## **AQUIND INTERCONNECTOR**

Consultation Report – Appendix 1.7H Marine  
Specific – Briefing Note for Ongoing  
Consultation with Southern IFCA August  
2019

Natural Power Memorandum			
To	Southern IFCA	Date	August 2019
From	Natural Power	Ref.	1199529

## Briefing Note to inform Ongoing Consultation: Responses to PEIR feedback

TITLE:
Figure 9.6 South Marine Plan

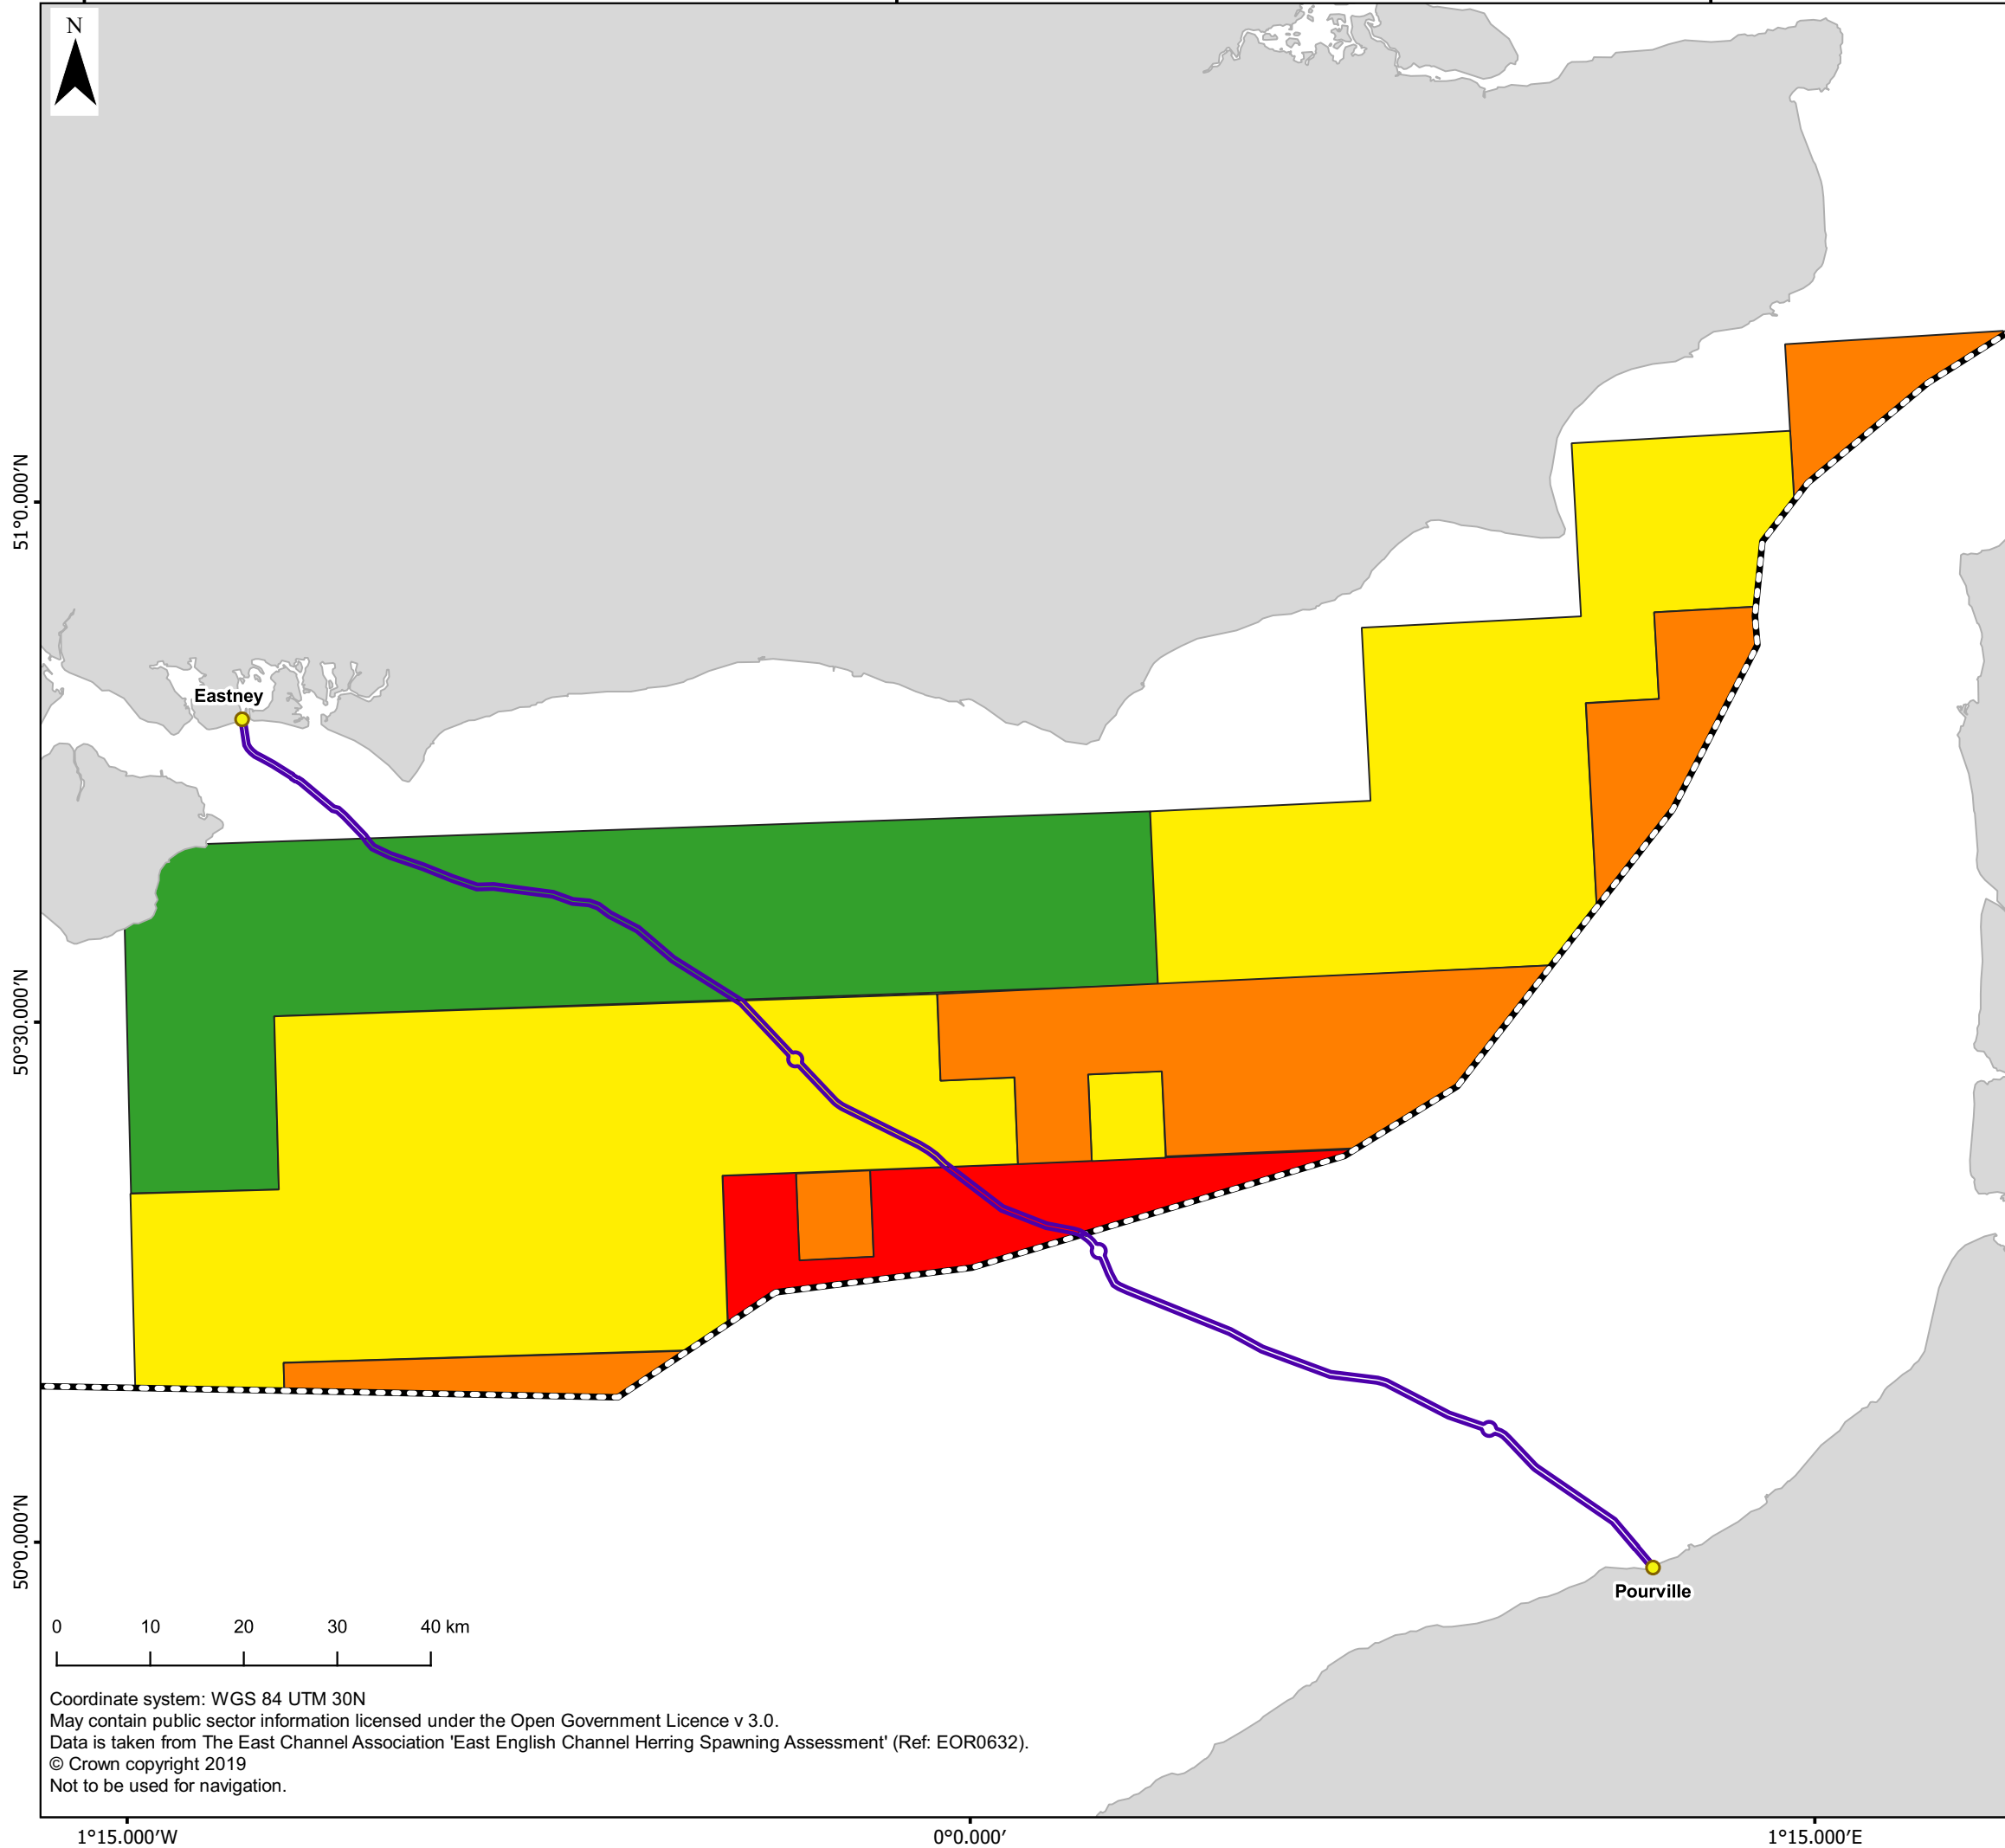
Item No.	Topic	Comment	Applicant's Response
1	<b>Marine Local</b>	Considering the project against the details included in the South Coast Marine Plan, S-Fish-2 states that: <i>“Proposals that may have significant adverse impacts on access to, or within, sustainable fishing or aquaculture sites must demonstrate that they will, in order of preference:</i> <i>a) avoid</i> <i>b) minimise</i> <i>c) mitigate significant adverse impacts</i> <i>d) If it is not possible to mitigate the significant adverse impacts, proposals should state the case for proceeding.”</i>	Chapter 12 of the final ES will present the updated assessment of the potential effects of the Proposed Development on fisheries. The design of the Proposed Development will be presented within Chapter 3 and has aimed to avoid and or minimise potential impacts on fisheries. Mitigation will be proposed where required.
2	<b>Commercial Fisheries</b>	The application highlights stakeholder consultation with the fishing industry has been undertaken in October 2017 and again in September 2018. Meetings have also been undertaken in September of 2018 with officers at Southern IFCA regarding the potential impacts to the fishing industry. This is appreciated and the importance of early stakeholder engagement was highlighted in our response to the scoping response.	Acknowledged. Subsequent consultation meetings were also held with commercial fisheries stakeholders as well as recreational anglers in March and April 2019.

Item No.	Topic	Comment	Applicant's Response
			<p>Noted. A more thorough consideration of South Marine Plan Policies will be included as part of the DCO application. It is also important to highlight for Nationally Significant Infrastructure Projects (NSIPs) such as the AQUIND Interconnector, the primary planning documents are the UK National Policy Statements (NPS), in this case NPS EN-1, and only regard needs to be had to the South Marine Plan when determining the DCO application.</p>
5	<b>Commercial Fisheries</b>	<p>Although not considered a requirement for the application, the developer may look to consider the relevant projects/organisations which look to support the fishing industry. Within the Solent in particular there is the Blue Marine Foundation, which is currently working as part of the Solent Oyster Project and may be worth including in consultation and may be able to provide avenues/opportunities to support a sustainable inshore fishing industry indirectly.</p>	<p>Further engagement has been ongoing to better understand the locations and current state of native oyster stocks within the Solent. This information will inform the assessment examining any potential effects on this receptor. Although the Blue Marine Foundation has not been consulted to date this comment has been acknowledged.</p>

TITLE:
 Figure 13. Fisheries in the Solent, based on consultation with Southern IFCA

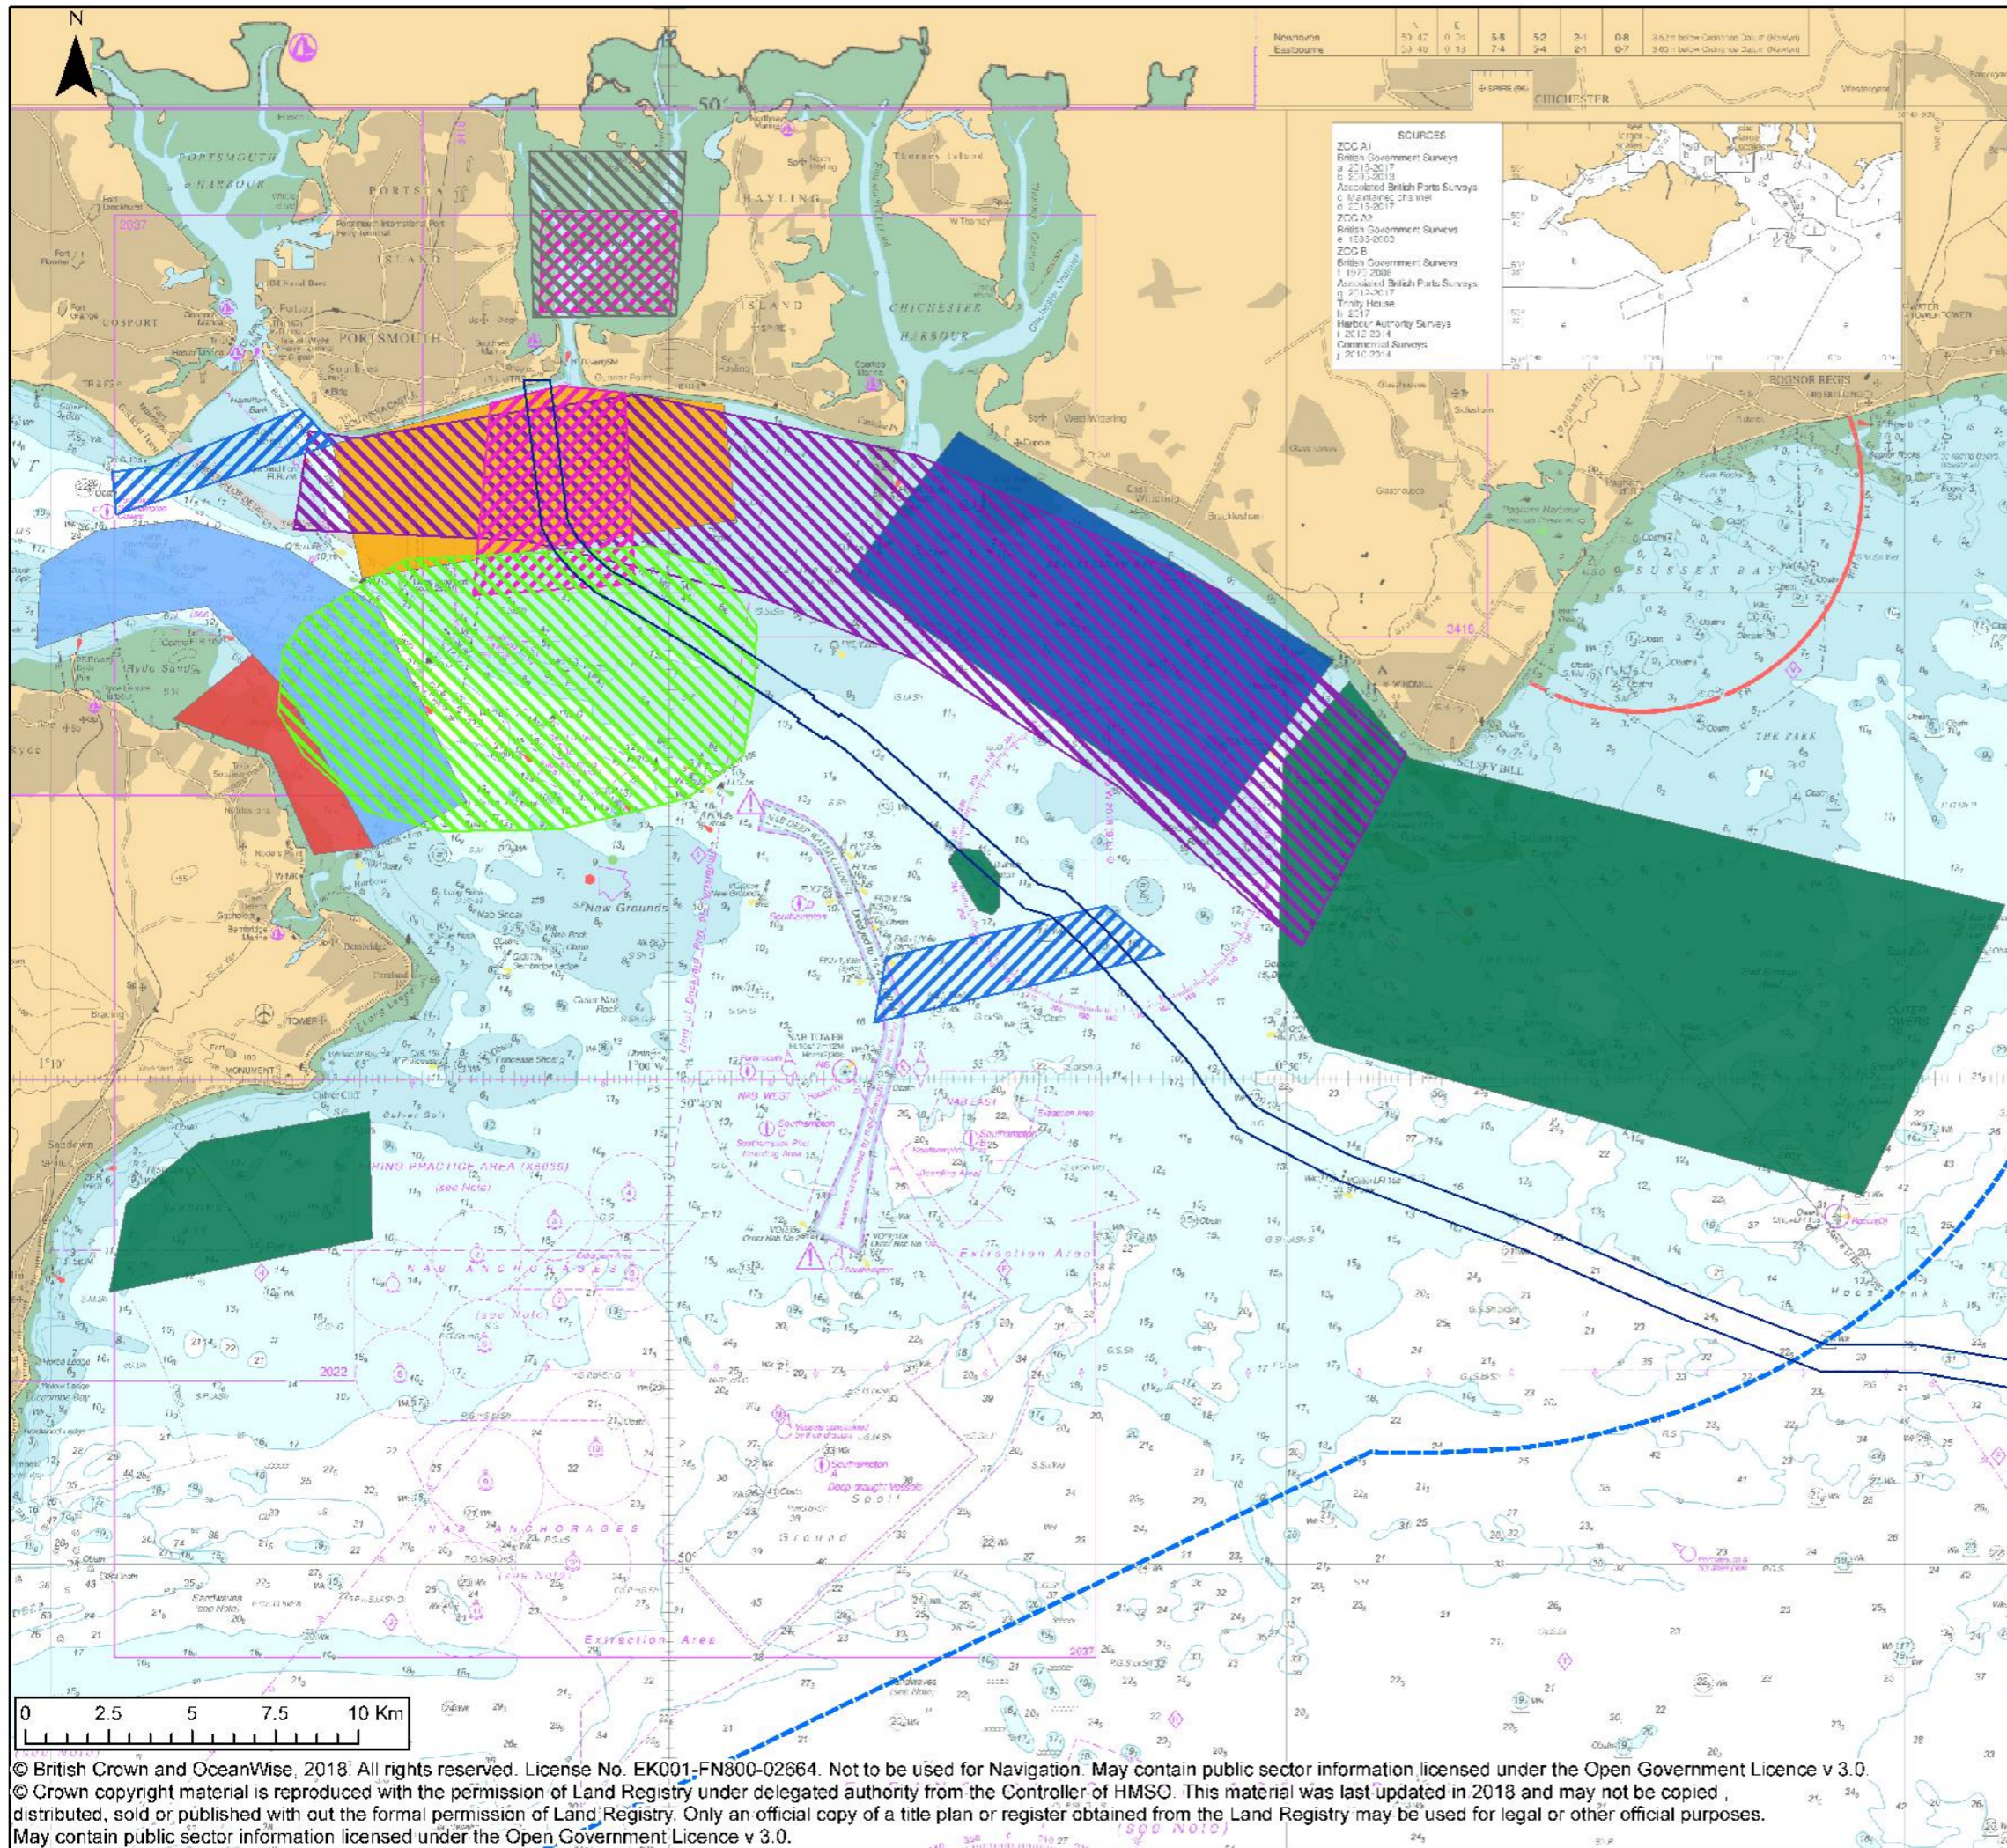
3	<b>Commercial Fisheries</b>	The assessment of fishing activities in the inshore region is difficult given the sources of information available, particularly the MMO landings, VMS data and surveillance data. The description of fisheries within the area seems apt particularly when applied to the Solent fisheries, identifying a number of	Chapter 12 Commercial Fisheries assessment has been updated to acknowledge the limitations that only looking at datasets can incur. The chapter will also make reference and consider the additional restrictions that the inshore fleet are subject to.

Item No.	Topic	Comment	Applicant's Response
		<p>the key target species and the nature of the inshore fleet as predominantly under 10 metre and multi-faceted in the species they target or gear they use. It is appreciated that the impacted area may be considered small, however the assessment that the inshore fleet can move, or switch gears, may not accurately reflect the adaptability of inshore fishing vessels. The limited availability of quota, restrictions on bass fishing, Marine Protected Area regulations and other marine works, particularly in areas such as the Solent, limit the adaptability of the fleet. The options to diversify when ground is lost is limited by the above factors, and those fisheries which could be considered alternatives are typically subject to their own seasonal trend and catch fluctuations. It is noted that a cumulative assessment will be made considering other marine works, it may be appropriate to consider other non-construction impacts the fisheries may be subject to, such as those mentioned above when considering the impact to the fishery.</p>	<p>These additional pressures will also be considered when assessing the cumulative and in combination effects on onshore fisheries.</p>
